Consultation Response from KC, Highways Development Management (HDM)		
2023/91212 Land off Bankfield Drive, Holmebridge, Holmfirth, HD9 2PH		
Erection of 21 dwellings with access from Laithe Avenue		
Date Responded: 14/10/24	Responding Officer: A.Darwin	Responding Ref: HDC 3-26/3

RECOMMENDATION: No objection, subject to Conditions / S106

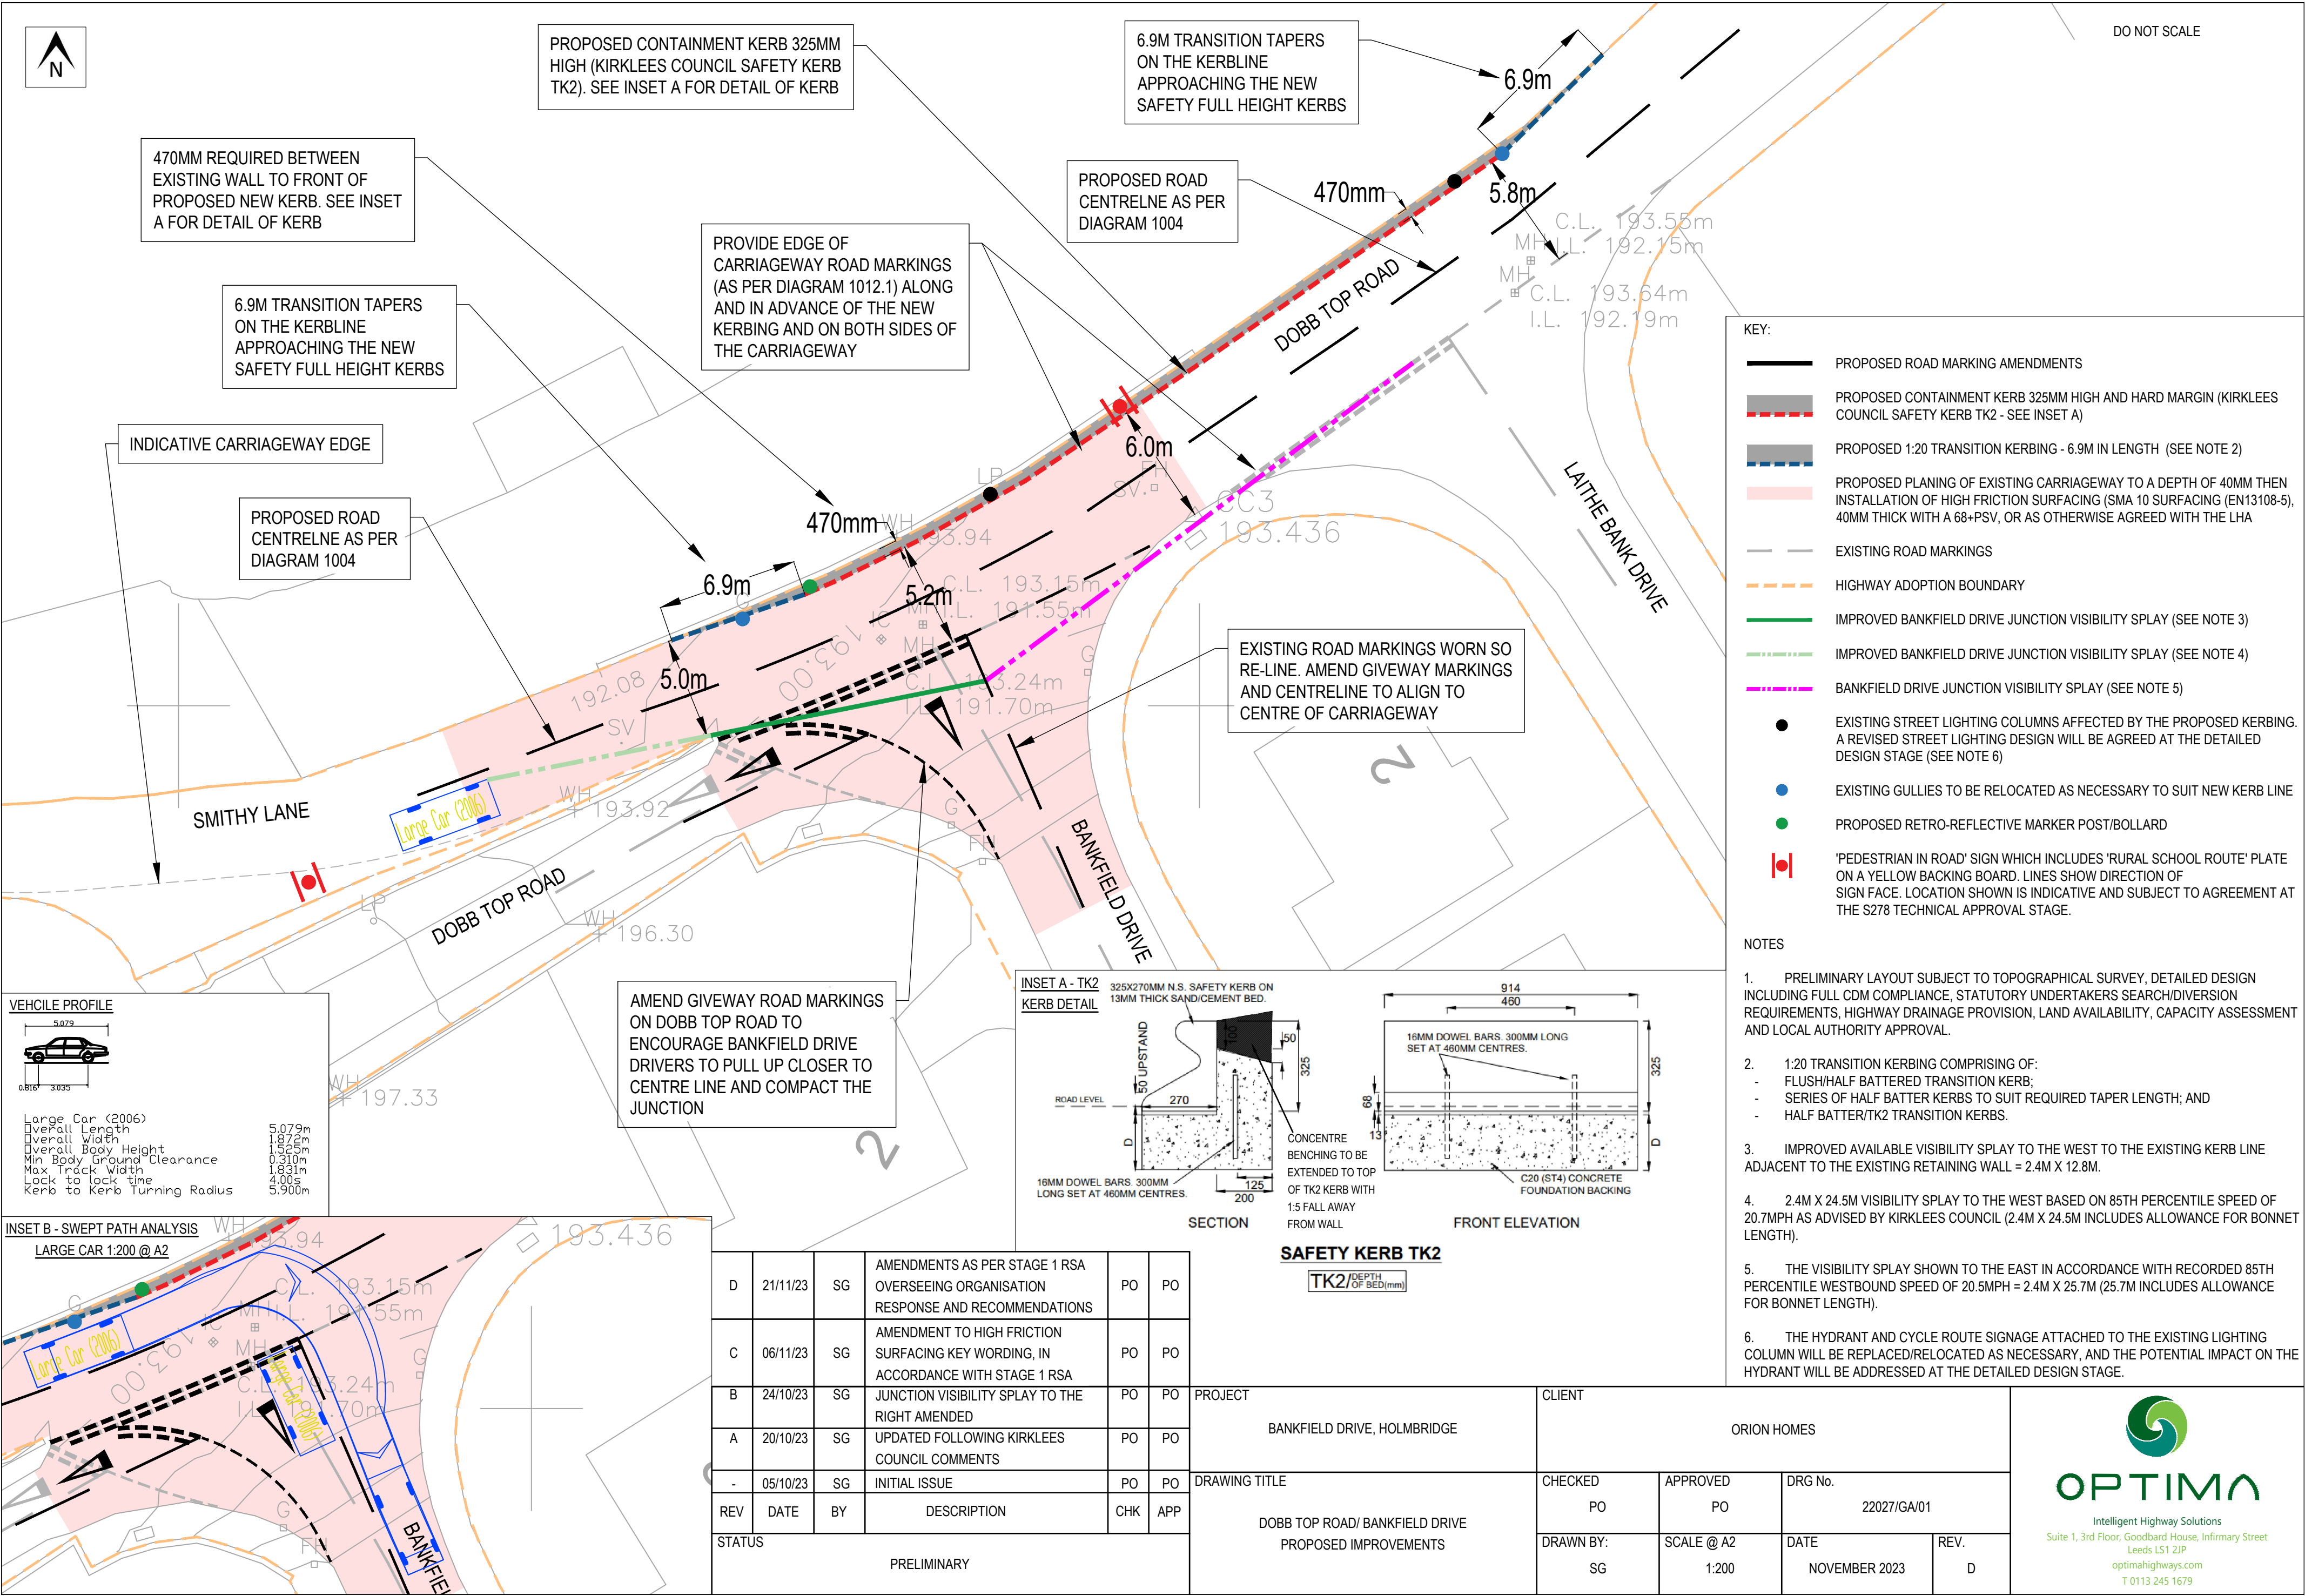
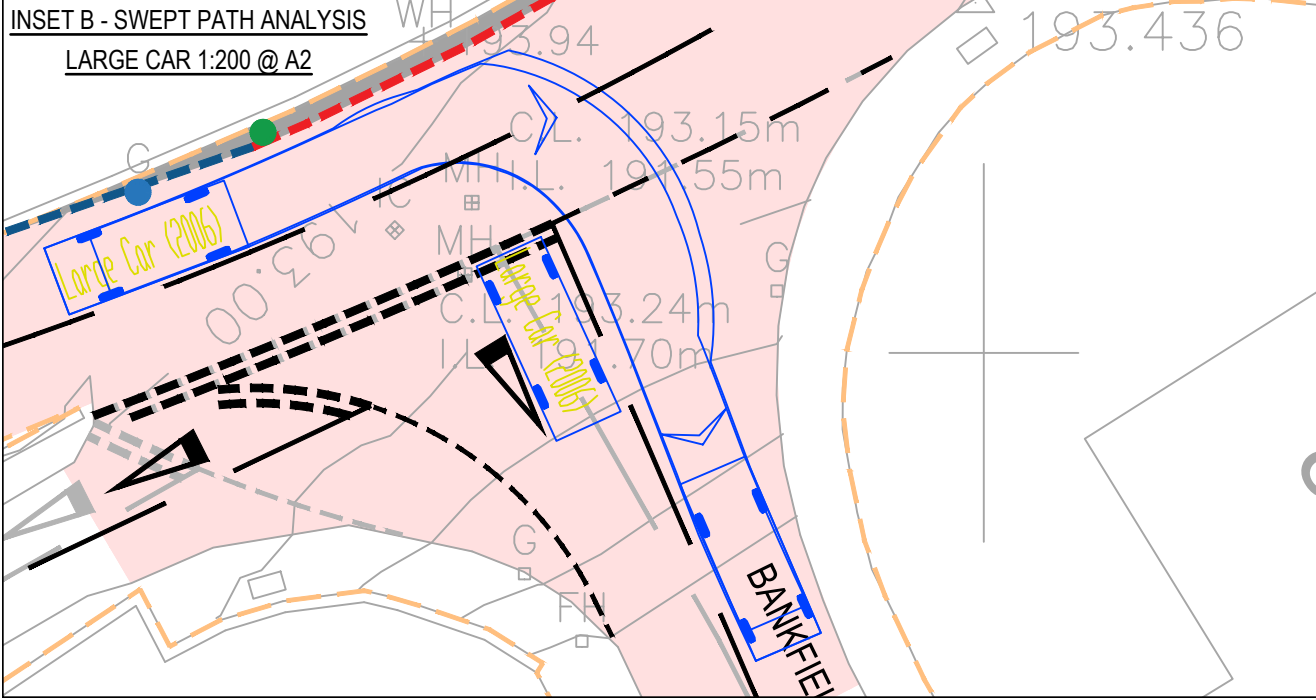
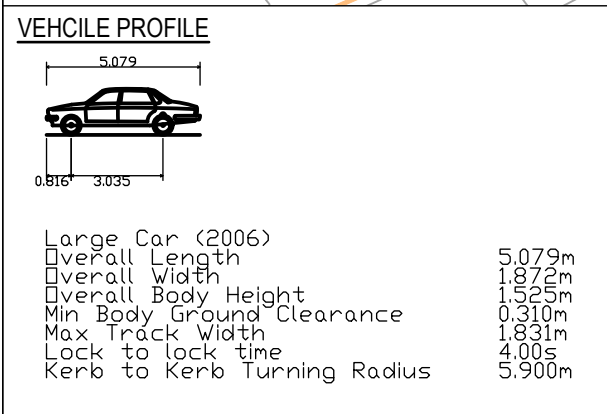
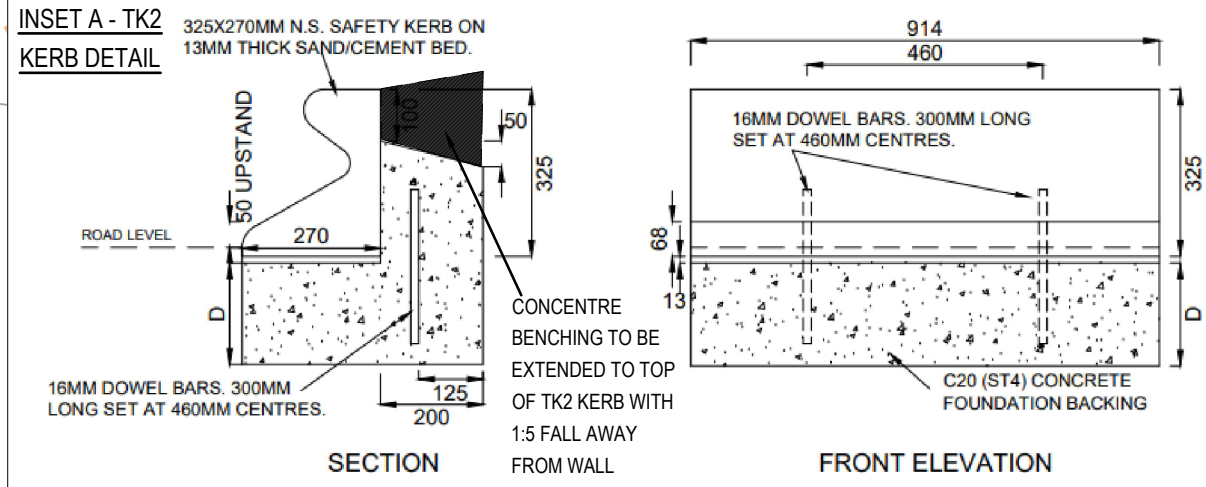
Subsequently, the applicant has provided additional supporting information and proposed a package of improvement measures at the Bankfield Drive and Laithe Bank Drive junctions with Dobb Top Road, as shown on drawing 22027/GA/01 Rev D. These works have been subject to a Stage 1 Road Safety Audit, which has not identified any issues that will prevent the works from being deliverable and are acceptable.

Visibility from the Bankfield Drive minor arm looking west (to the left) towards approaching traffic from Smithy Lane is currently restricted due to the presence of a dry stone wall. Therefore, improvements to the junctions road markings are proposed to improve visibility. This includes amendments to the centreline on the Bankfield Drive minor arm, and changes to the give-way lines on the adjacent junction with Dobb Top Road. These changes are intended to make the junction more compact, and encourage drivers waiting to enter Smithy Lane to position their vehicle further to the east, where the sight line to/from approaching traffic from Smithy Lane to the west are improved. Based on these proposed road marking changes, the submission drawings have demonstrated that approaching vehicles can be observed from a distance of 24.5m, which is adequate based on the recorded 85th percentile approach speeds of 20.7mph of passing traffic and guidance contained in 'Manual for Streets'.

In addition to the benefits of the amended road markings to the users of Bankfield Drive, the changes to the give-way line position for the adjacent Dobb Top Road junction (e.g. bringing the give-way line forward) will improve visibility for vehicles exiting Dobb Top Road, to the benefit of these users.

The proposals also include additional centreline markings on Dobb Top Road / Smithy Lane and edge of carriageway markings, as recommended by the Stage 1 Road Safety Audit.

Therefore, to address the above issue, the applicant has agreed to provide new containment kerbs on the north side of Dobb Top Road, opposite both the Bankfield Drive and Laithe Bank Drive junctions. Whilst the containment kerbing would not prevent a junction overshoot incident occurring, it would reduce the safety risk of vehicles striking the wall and then creating gaps. This would reduce the risk of an errant vehicle crashing through the wall, and help to mitigate the secondary risk of gaps in the wall that affect other highway users (e.g. passing pedestrians).

To reduce the risk of vehicles skidding on the Bankfield Drive approach to Dobb Top Road (which is likely to be the primary route to and from the site) the applicant has proposed to resurface the Bankfield Drive minor arm approach with high friction surfacing (HFS with 68+PSV), which would help address overshoot incidents in dry and wet conditions.

In addition to the Bankfield Drive approach to the junction, the full extent of the junction would be resurfaced with HFS, including the Dobb Top Road approach to the west, which should reduce the risk of vehicles skidding on all approaches.

Prior to occupation of the development, the off-site highway works as shown on plan 22027/GA/01 Rev. D; comprising junction visibility, kerbing, signing, road marking, surfacing improvements and associated works at the Bankfield Drive and Laithe Bank Drive junctions with Dobb Top Road shall be fully constructed and made operational.
